Examining Authority Questions of 5 June 2019

SMBC response

Figure 3-4 - Extent of Bickenhill Conservation Area (shown in purple)

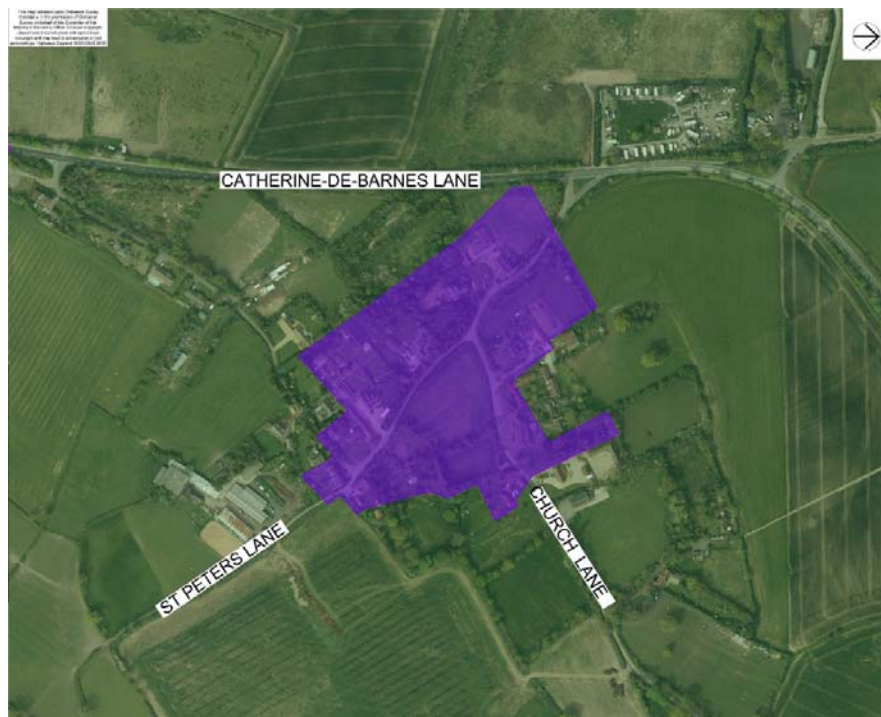
The Council agrees that *‘Impacts of Construction’* at 7.9.20 would adversely impact **Bickenhill Conservation Area**. The link road would occupy land within the designation at its western extreme, closer to listed buildings including the Grade I **Church of St Peter** than the existing, narrower B4102. Some new road would be on embankments up to 3 metres high. The field provides continuity in the setting of the **Bickenhill Conservation Area** and **St. Peter**, maintaining the foreground of a rural village landscape seen from Catherine de Barnes Lane. The weight given to existing influences upon

At 7.9.37 Impacts of operation **Bickenhill Conservation Area** is reported to experience **No Change** during operation because the link is in cutting. The Council does not agree; the scheme cuts into **Bickenhill Conservation Area** and rises from cutting through grade to low embankment. Clock Interchange widens to three lanes, with lighting impacts. The impact must be **Moderate/ Slight** or **Moderate/ Large**. Operation will produce increased traffic, noise and lighting overspill. The **Major Adverse** Impact and **Large Adverse** significance of effect in Landscape (chapter 8) contrasts with chapter 7 conclusions, and supports the Council's contention that impacts upon **Bickenhill Conservation Area** would be greater. Furthermore, 5.3.46 in the Planning Statement and National Policy Statement Accordance Table states that **Bickenhill Conservation Area** will suffer a **significant effect** but not substantial harm (5.3.47).

The road position within **Bickenhill Conservation Area** would remove part of a field and introduce the link, roundabout, cutting, lighting and barriers as adverse change harming its setting.
